Formal planning objection submission

Garden House,
Lower Common Lane,
Scissett.
HD8 9HL

Application reference number: 2026/62/90452/E

Proposed Front Elevation (North west) 1:100

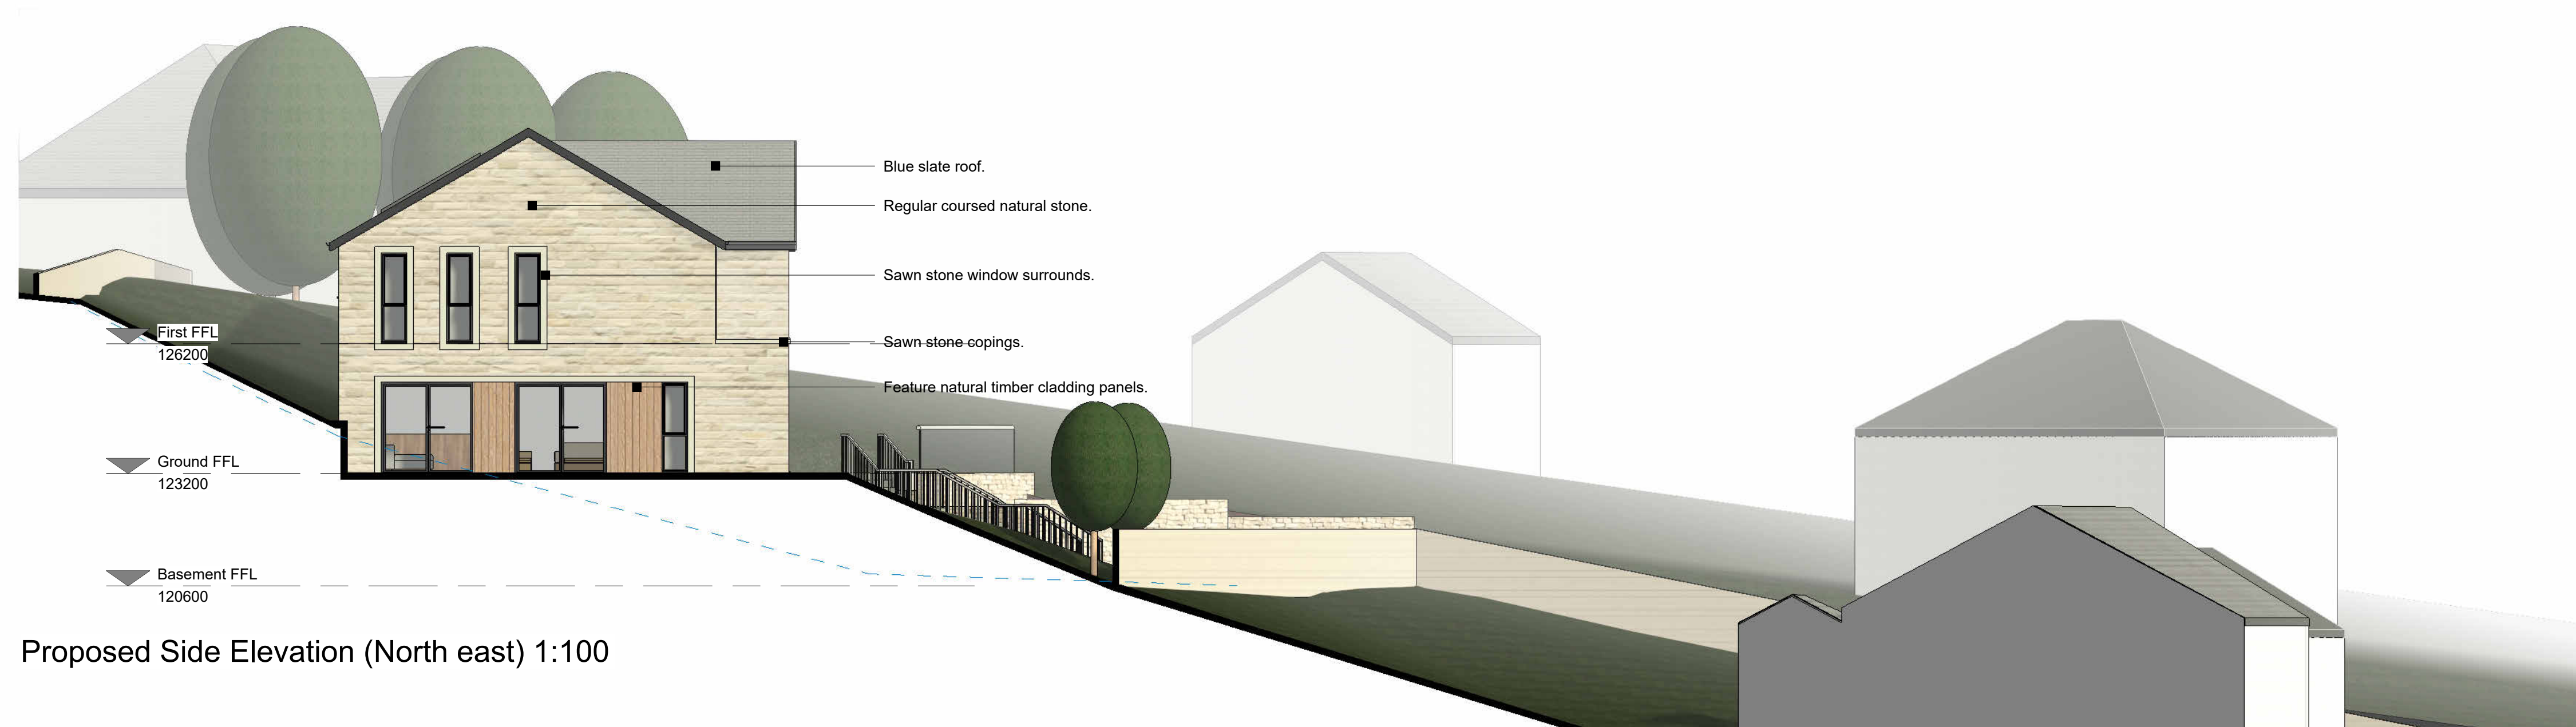
My third objection is the **right to privacy** under Article 8 of the Human Rights Act 1998. This Article protects the right to respect for your private and family life, your home and correspondence. including the right to enjoy ones home without unjustified intrusion. The proposed development includes a substantial glass fronted elevation and balcony facing directly towards several neighbouring properties and located approximately 19 metres from residential homes and within 10 meters of neighbouring boundaries.

The scale, transparency, and orientation of this glazed façade as well as the balcony would result in significant and unavoidable overlooking into private gardens and habitable rooms. This represents a material loss of privacy and an unjustified interference with the rights protected under Article 8. No meaningful mitigation has been proposed, and the design fails to safeguard the reasonable expectation of privacy that residents are entitled to. The proposal therefore conflicts with both Article 8 and local planning policies relating to residential amenity. The scale and positioning of the building would create an overbearing

Proposed Site Plan 1:200

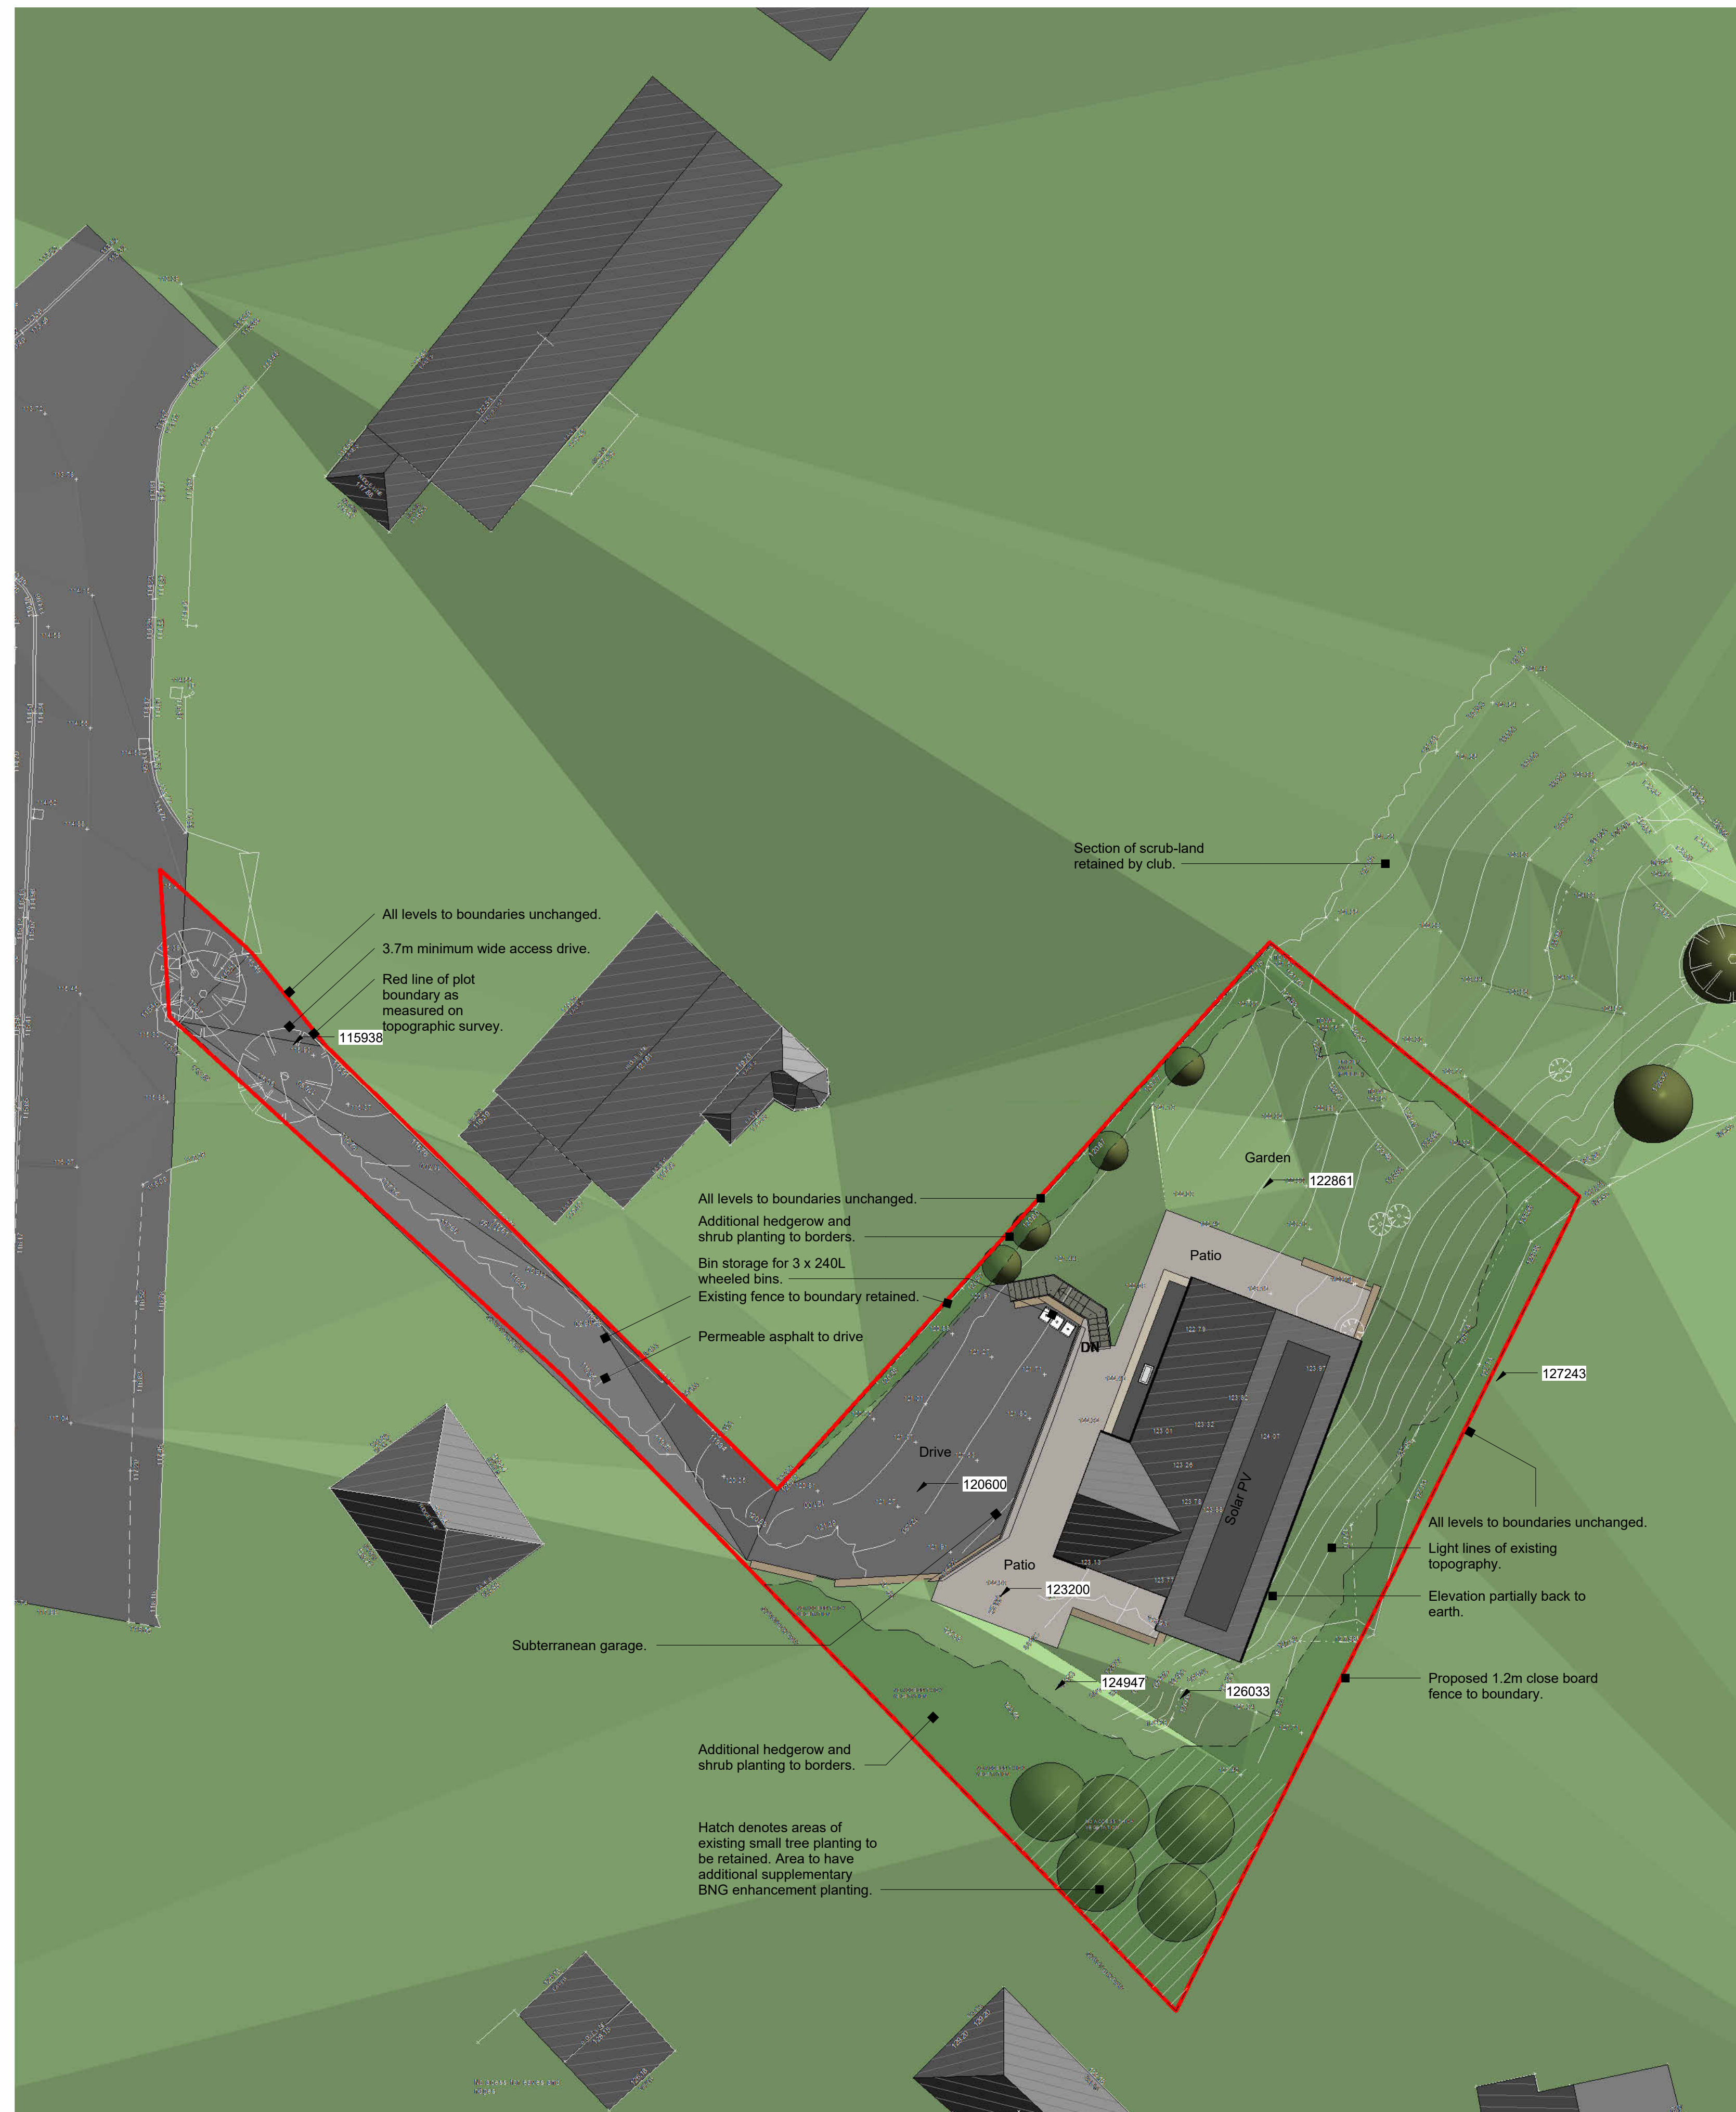
The proposed access arrangements are unsafe, substandard, and contrary to national and local highways design requirements. The development relies on a stated 3.7-metre-wide access however at points of the driveway this reduces down to nearer 3 meters, which is only marginally above the minimum width required for a single dwelling. There is no clear agreed boundary and this width would take up all the hedgerows of the boundary and more.

The proposed access road neighbours other existing shared accesses and is in close proximity to a road junction, and directly opposite a nursery car park. The access is further constrained by the fact that the adjacent property holds a legal right of way over the entrance and the land in question. This configuration presents significant safety concerns with the addition of four cars, deliveries etc. construction traffic and emergency service vehicles using the access road including:

- increased likelihood of vehicles reversing onto the highway
- insufficient junction spacing
- difficulty achieving required visibility splays due to the angle of the drive
- increased conflict points near the junction
- No provision for road side bin collection for all the adjacent driveways without blocking pedestrian walkways

**Figure 1:** UK HABS Baseline Habitat Classification Map for the Development Site

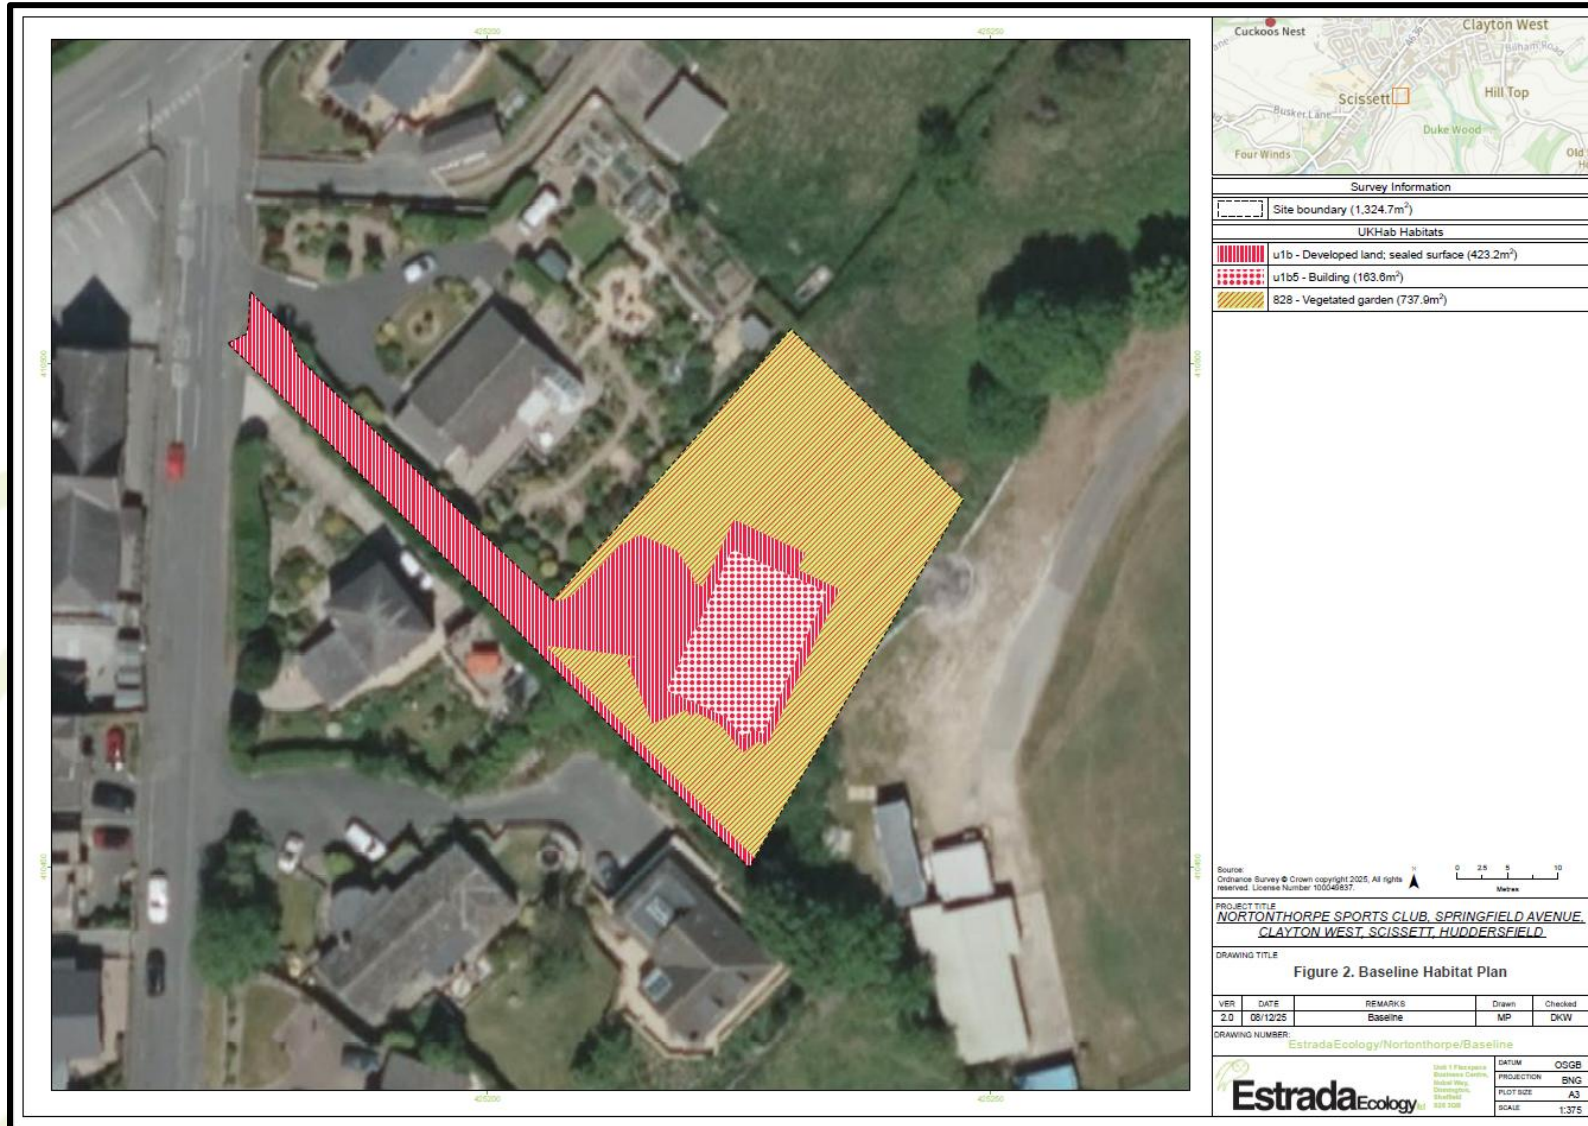
The application fails to meet these requirements. Shown in the applications biodiversity report;

*Overall Development 7.1 The proposal for the current development scheme **will result in a net loss of -1.72 habitat area units and -0.59 for linear hedgerow units, representing a -92.36% net loss for area habitat units and a -97.85% loss for linear hedgerow units.***

7.2 The Trading Summaries are not satisfied for this development proposal due to a net loss in medium-distinctiveness habitats which are not compensated for with units of the same broad habitat group or units of a higher distinctiveness.
